Application Reference: Y/70/22/DOC Site Name: Land at Blisham Road, Yapton	Initial Issue Date: 04/10/2022 Issue Date: 01/02/2024 Reviewer Reference:
---	---

Description of Works: Approval of details reserved by condition imposed under ref Y/91/17/OUT relating to Condition Nos 9 - surface water drainage and 27 - levels.

AQUACELL SURFACE WATER STORAGE TANK
(Scale 1:20)

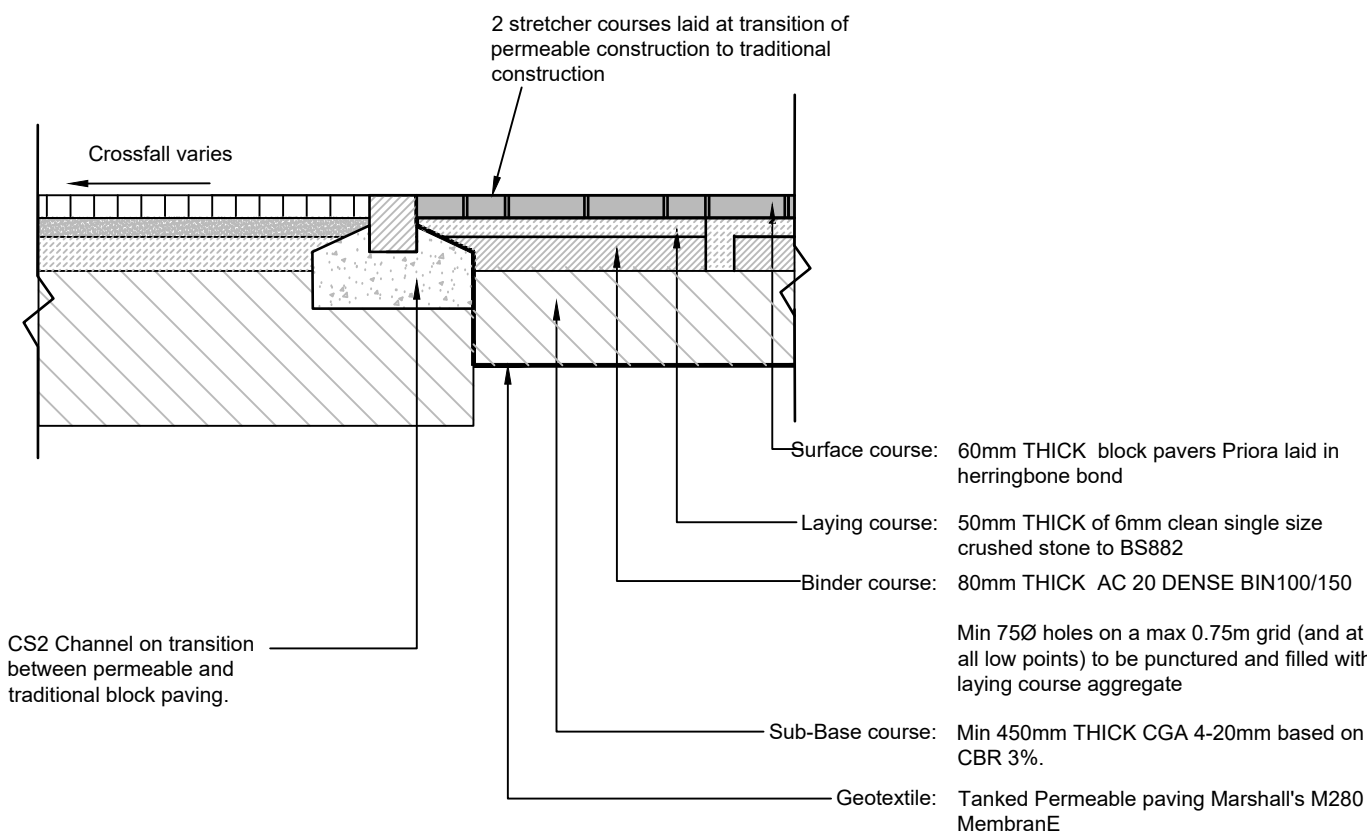
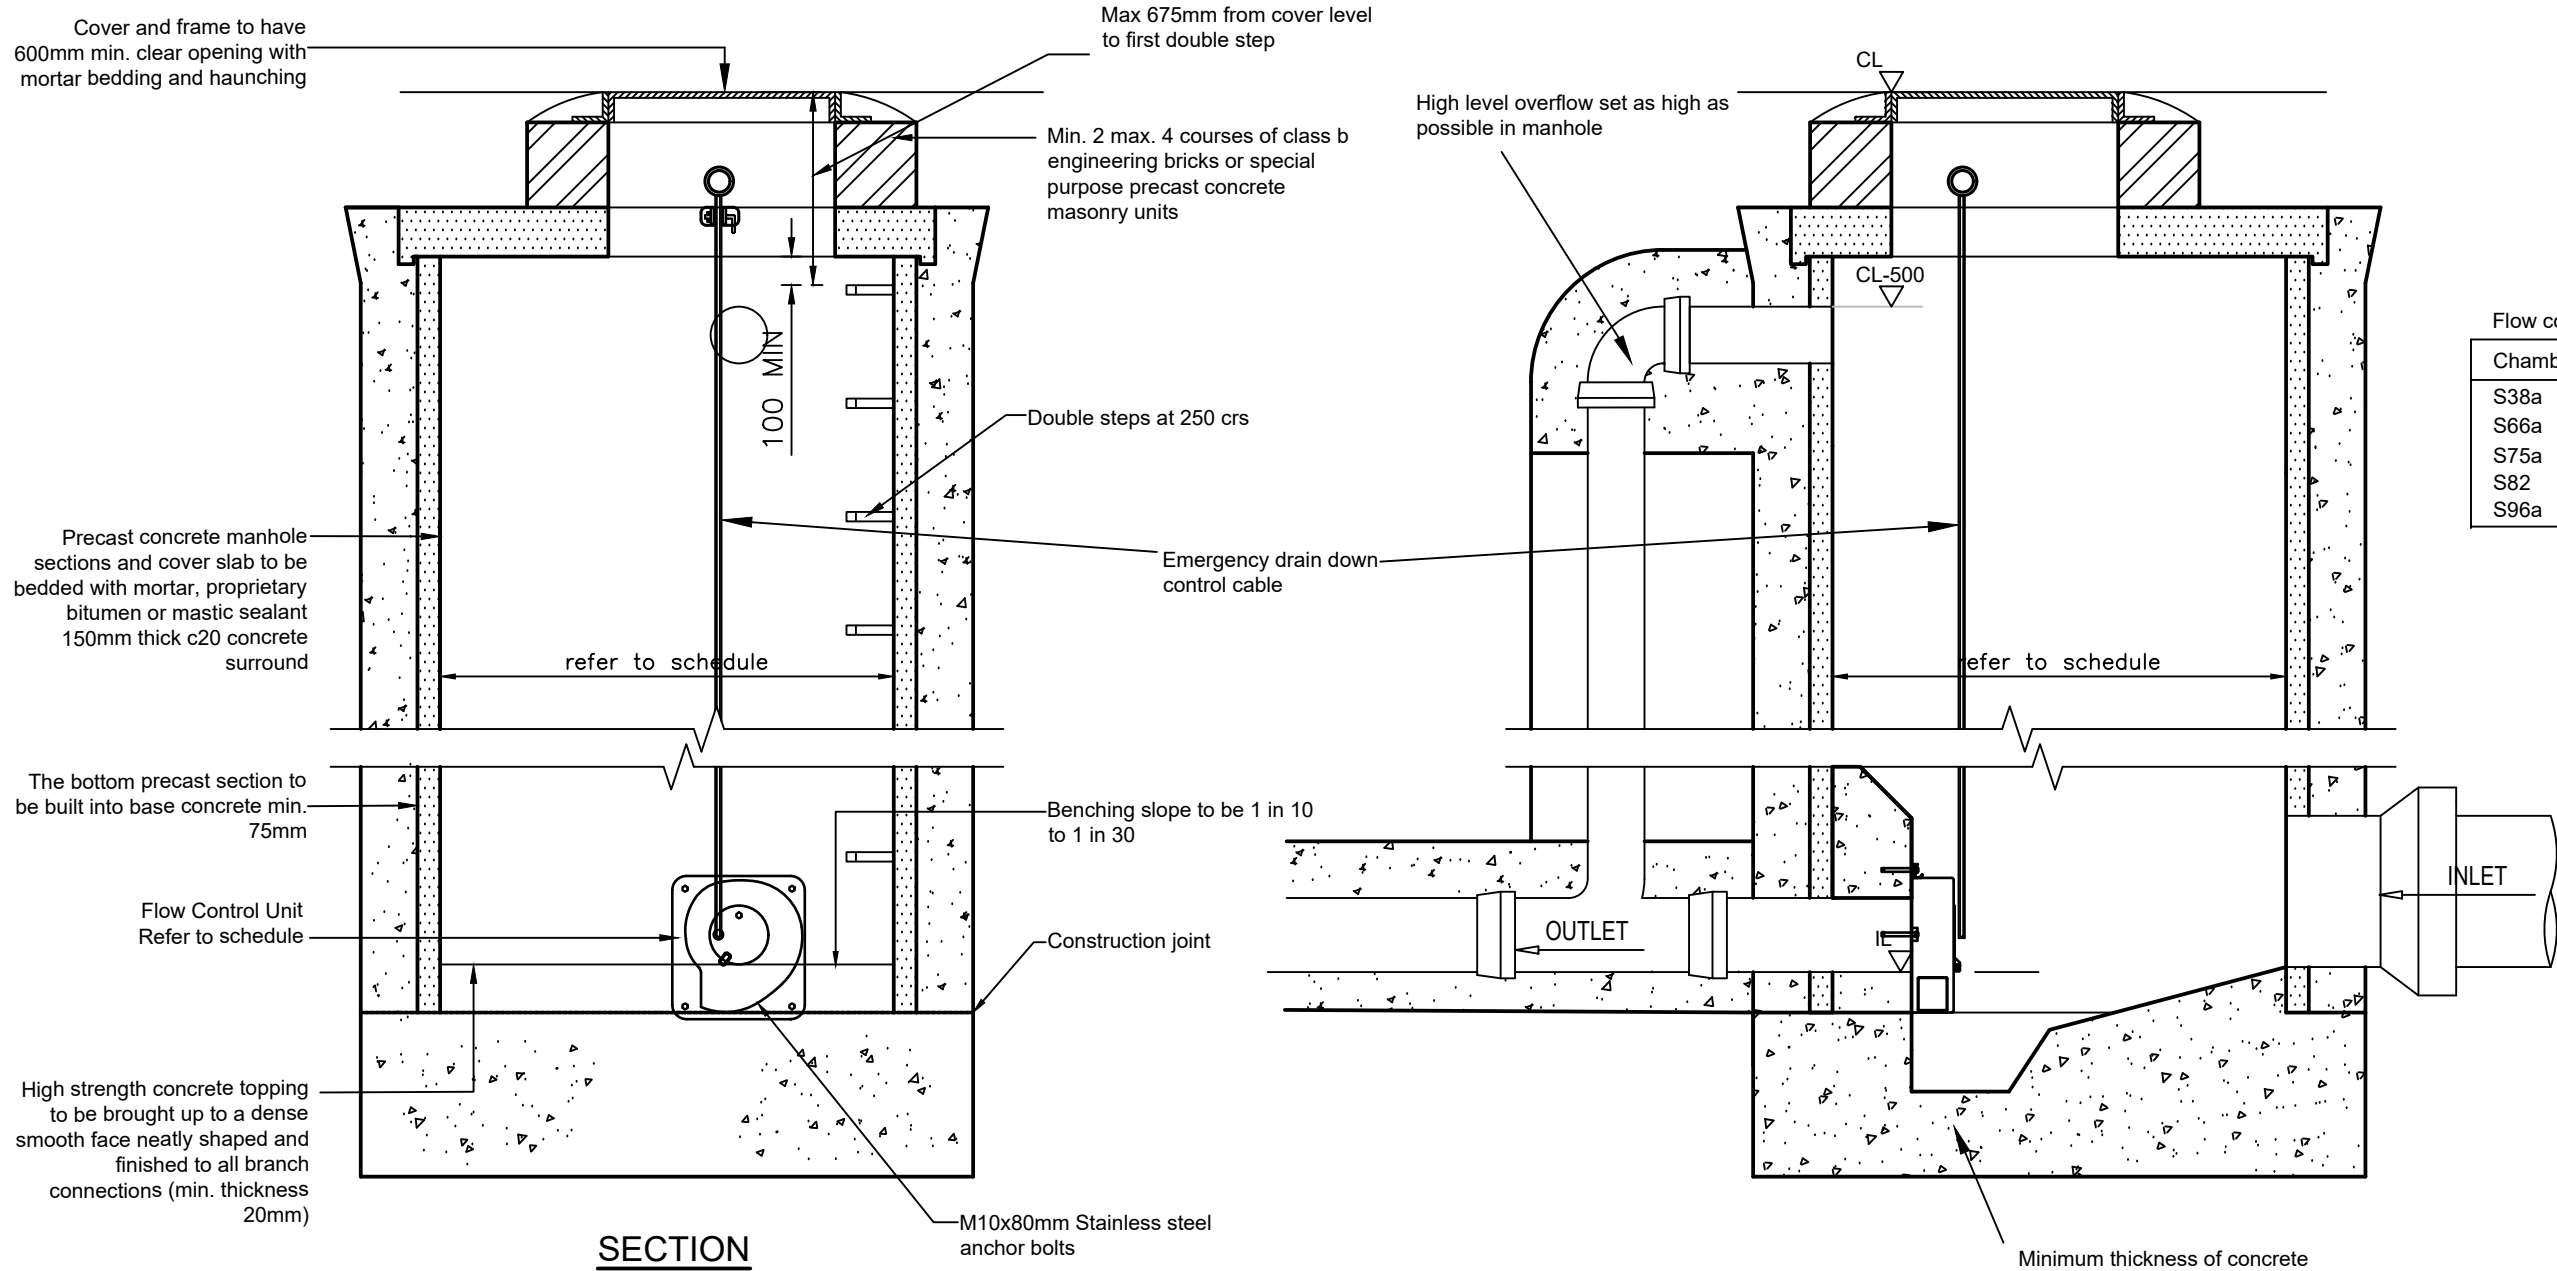
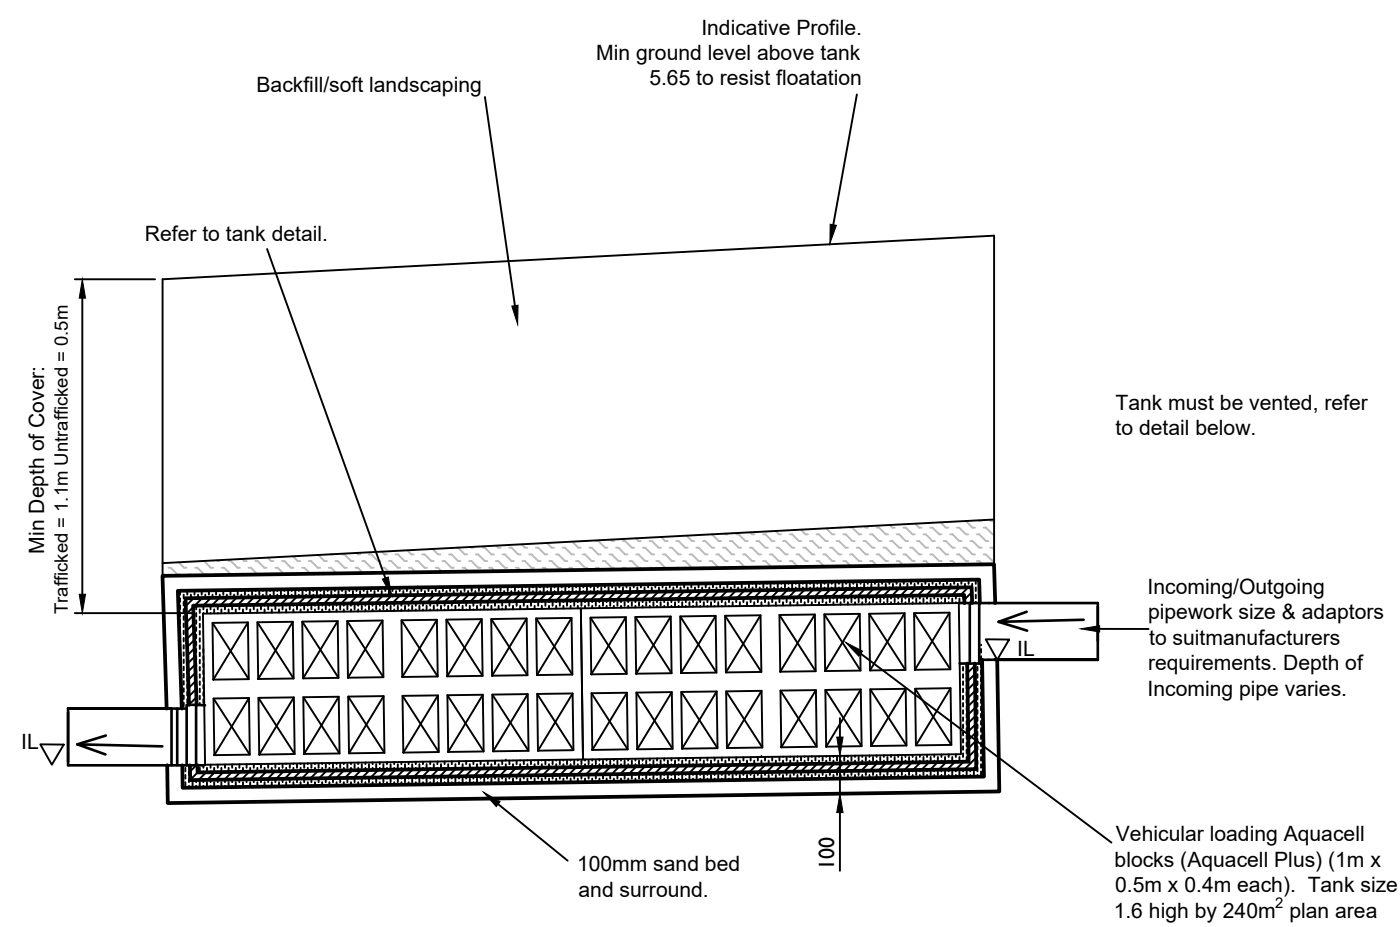
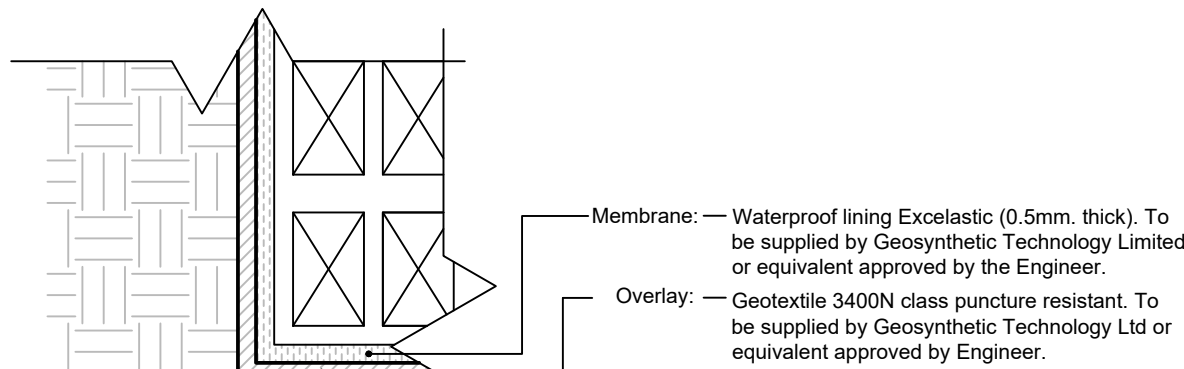
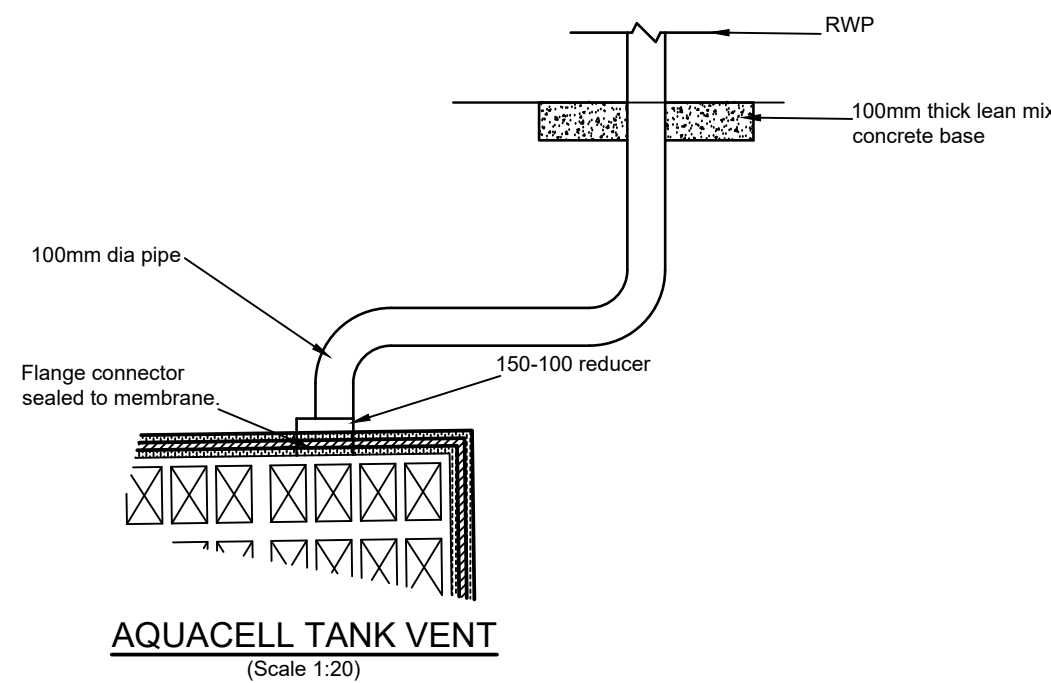
13.	There are inconsistencies between layout and details for the attenuation tank. Layout states a depth of tank of 1.5m but detail states a depth of 1.6m. Please ensure consistency.	The calculations still state 1.5m . Please also resubmit the construction details for this tank as part of this discharge application 08/2/2023- This has now been received and we have no further comments.	Closed
